Please ask for: Ms Iqraa Malik
Email: iqraa.malik@terraquest.co.uk
Telephone: 01212341390
Our Ref: BE/132/20/HH
Your Ref:
Date: 6th November 2020

Application for Planning Permission for Works or Extension to a Dwelling

Development: Proposed 2 storey rear extension
4m projection at first floor
7m projection at ground floor
open oak frame porch
Location: 394 Chichester Road North Bersted Bognor Regis PO21 5BU

GROUND FLOOR PLAN
SCALE- 1:100

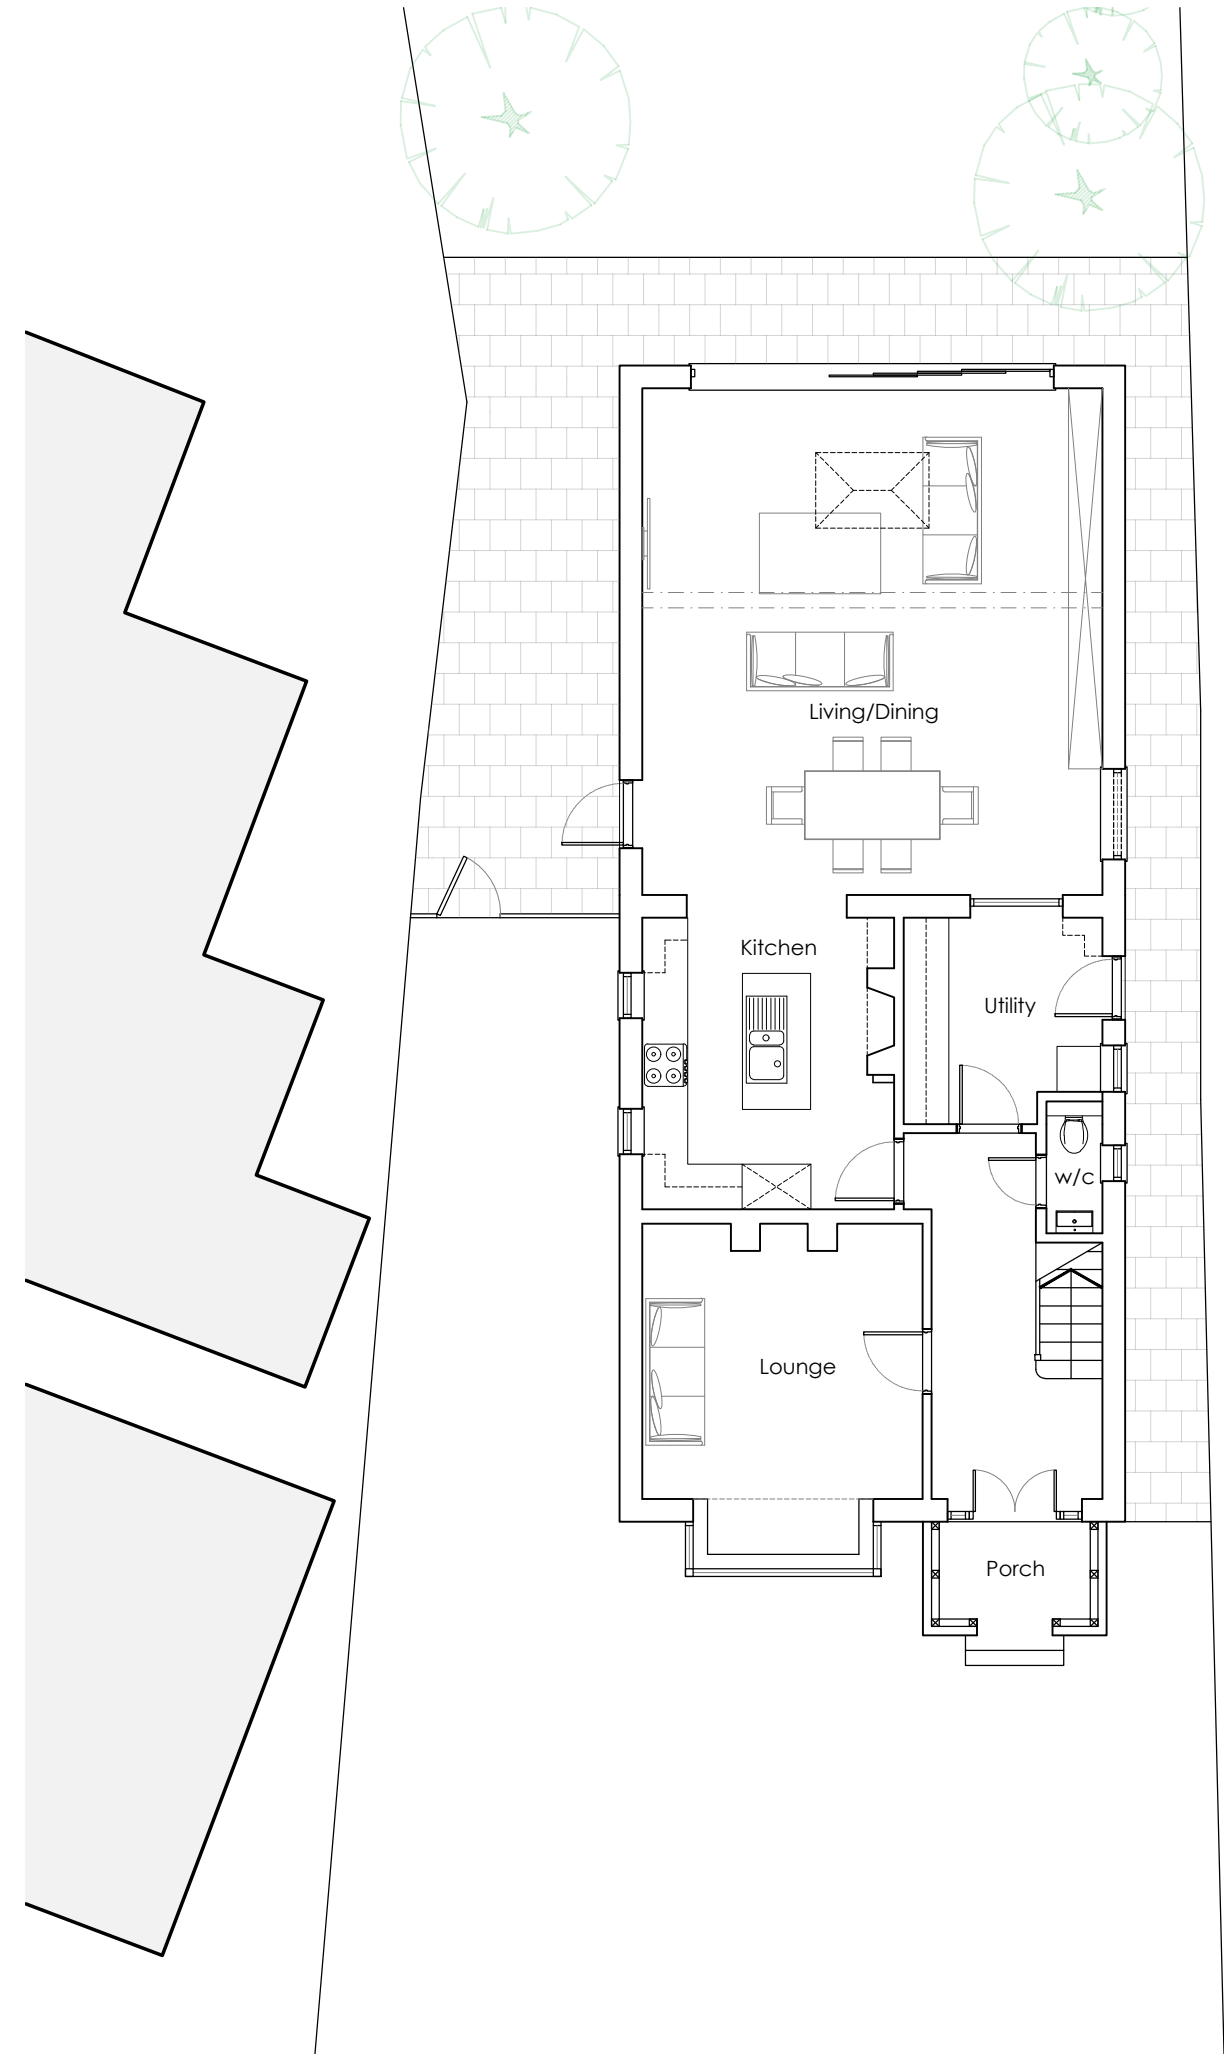
Ground floor plan and Eastern Elevation

The window shown in the utility room next to the door on the proposed ground floor plan is missing from the Eastern Elevation. Please amend.
